To: Richard W. Dineen/PLN/CABQ,
cc:
cc:
Subject: Deke Noftsker San Mateo & Beverly Hills

DRB Application No.: <u>04DRB-00036 (SDP)</u>	Project # <u>1002786</u>
Project Name: <u>North Albuquerque Acres</u>	EPC Application No.:
Agent: <u>James Miller</u>	Phone No.: <u>345-1312</u>

DEVELOPMENT REVIEW BOARD TRANSPORTATION DEVELOPMENT Standard Comment Sheet

DEVELOPMENT REVIEW BOARD--SPEED MEMO

Site Development Plan  
 for Building Permit  
**Site Plan**

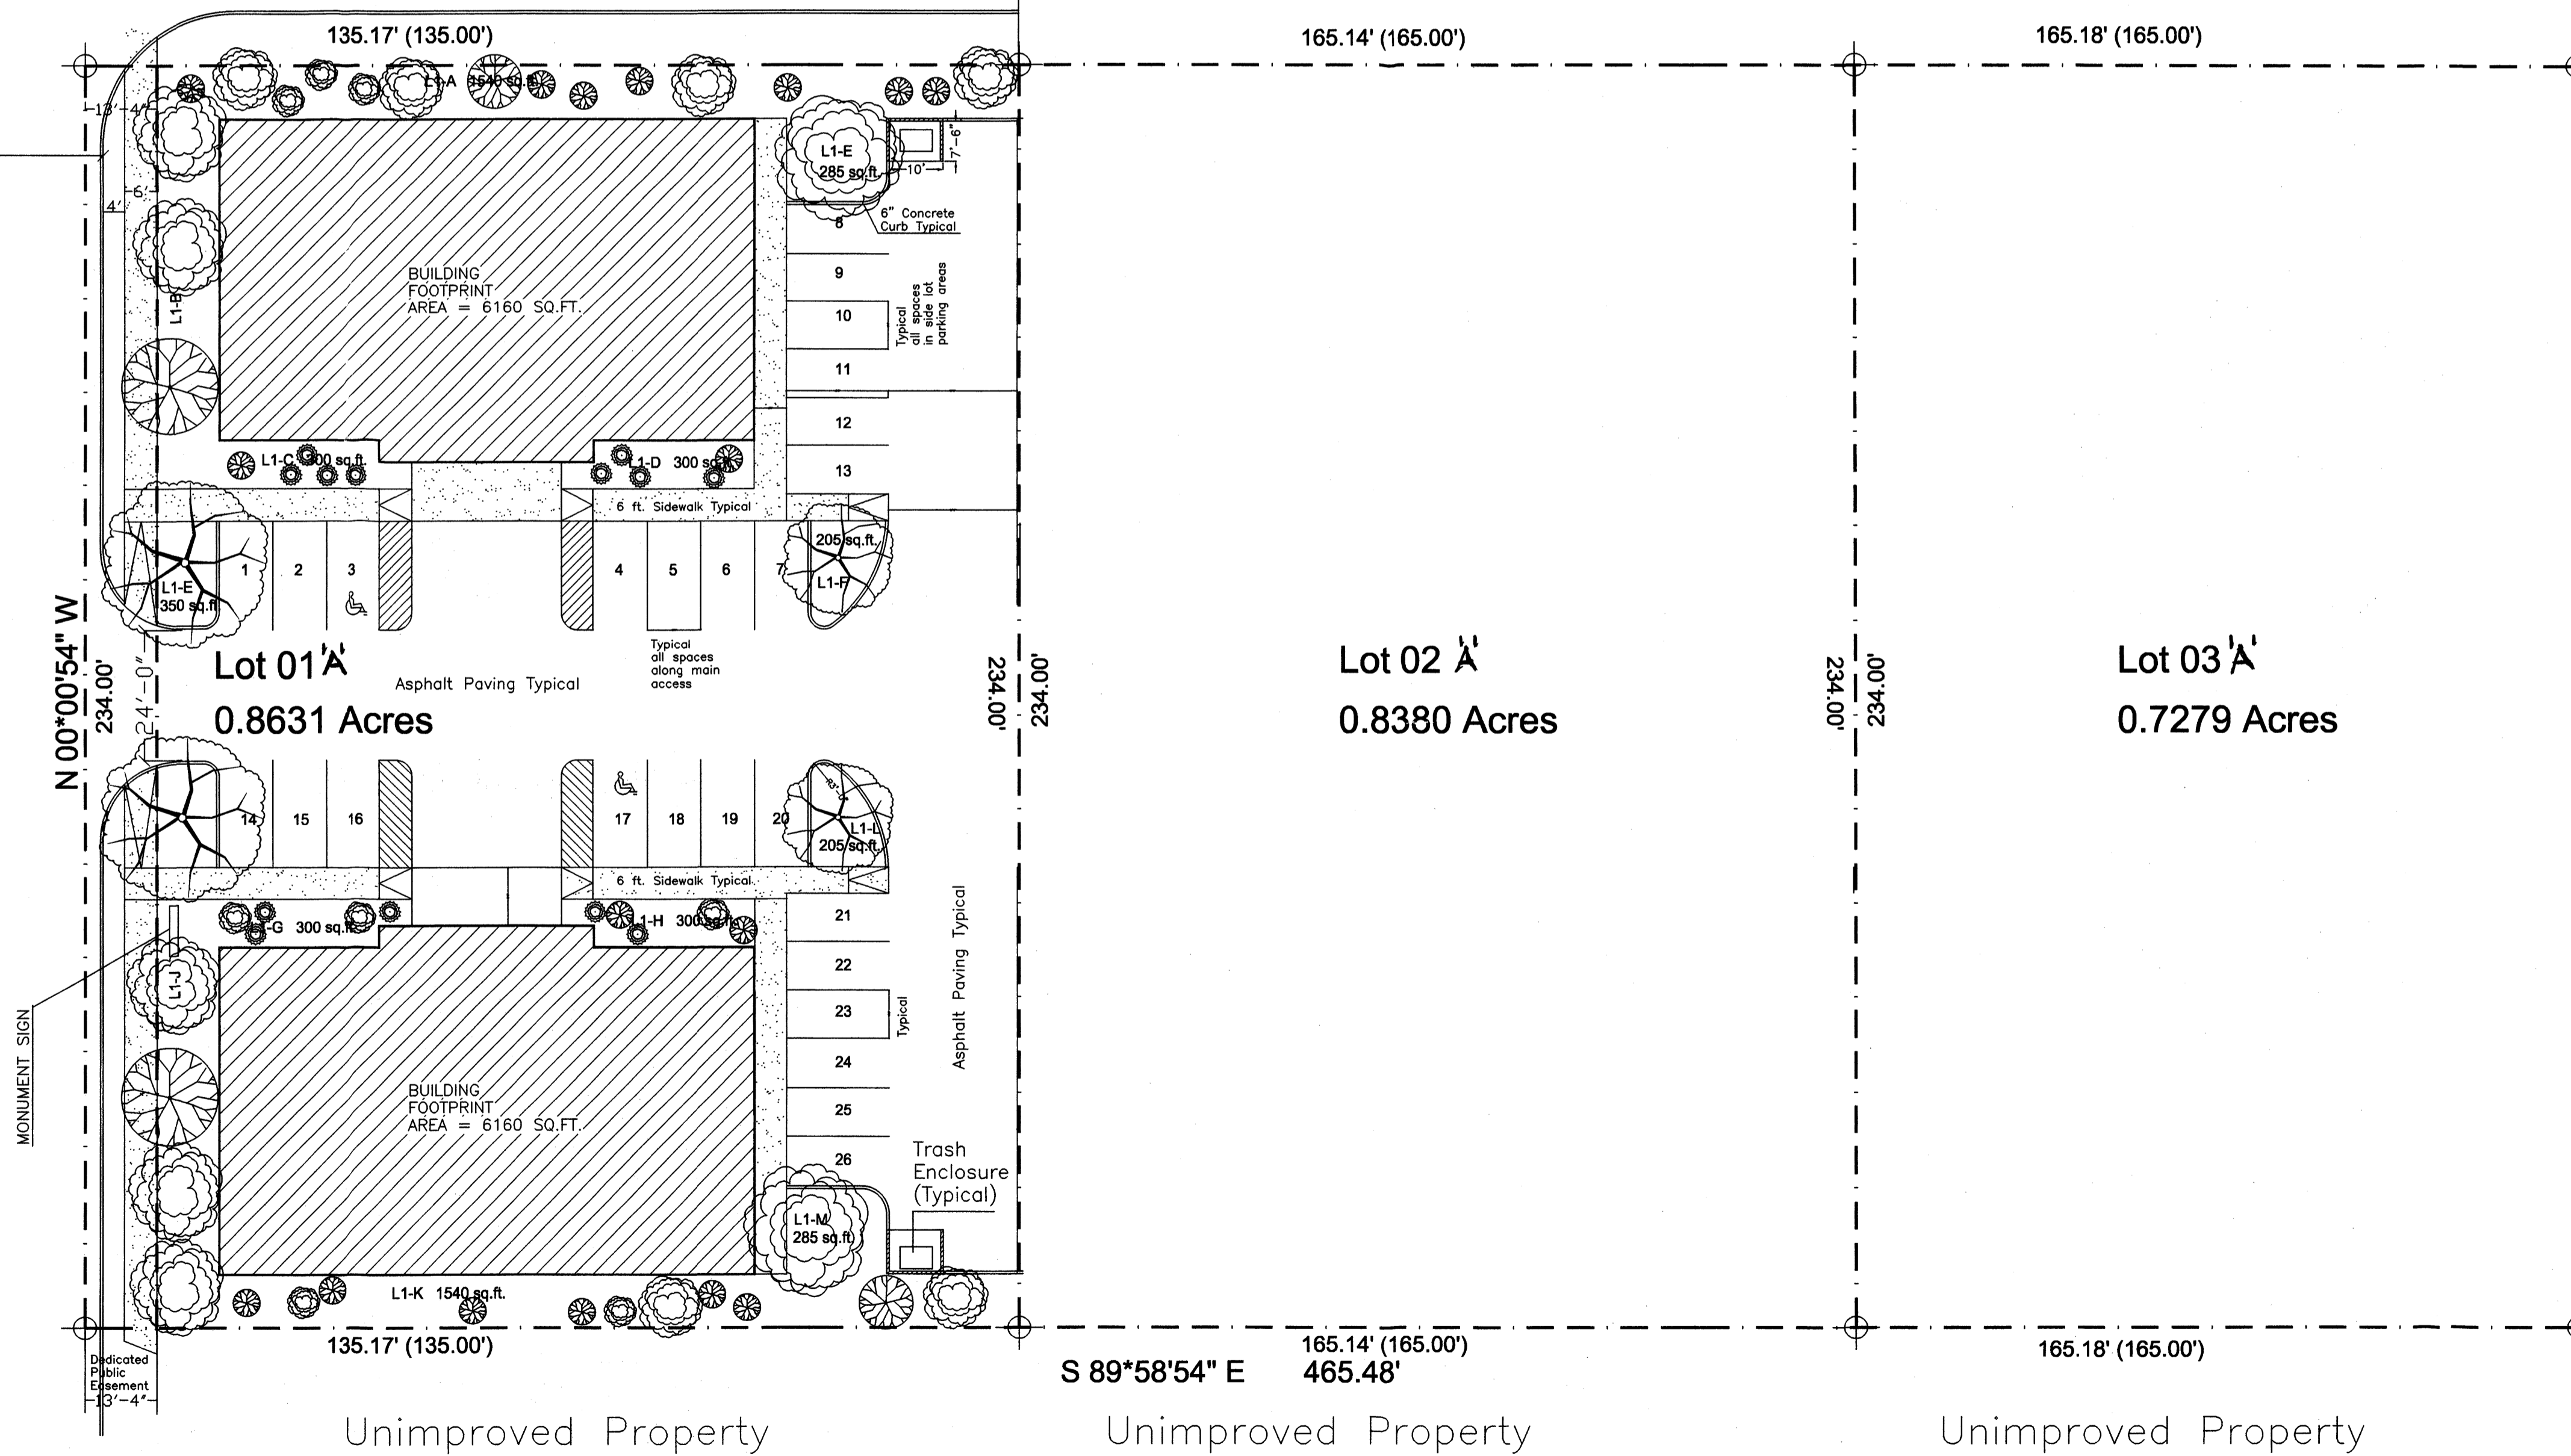
On January 21, 2004, DRB approved the amended SPBP & delegated it to Roger Green for a revised utility plan and to Brad Bingham for the SIA agreement, dimensioning of parking stalls & labeling of turning radii as well as AEHD signature & the standard note about Infrastructure List on the Site Plan. As you can see, we did Jim Miller a favor by assigning Brad the responsibility of looking for transportation & planning conditions in addition to the SIA. Otherwise, the site plan would have been deferred.

- SIA
- check ADA PARKING STALLS DIMENSIONS / RAMP HURDS LABELING
- Planning comments
- _____

CITY ENGINEER / AMAFCA: _____
 SIA
 - NEED ADA PARKING STALLS DIMENSIONS / RAMP HILLS LABELING
 Planning comments

No.	Comment
	- HAS SOLID WASTE APPROVED LOCATION OF REFUSE BINS?
	- LABEL / DIMENSION RADII & ADA PARKING SPACES
	- INFRA. LIST SHOULD LIST 24' of MATERIAL POINT on SIDE MATED. GEO-TECH INVESTIGATION WILL BE NEEDED TO DETERMINE IF X-SECTION IS ADEQUATE
	- SITE PLAN NEEDS TO LIST THAT "ALL IMPROVEMENTS in PUBLIC R.O.W REQUIRE DRB APPROVED PLANS"
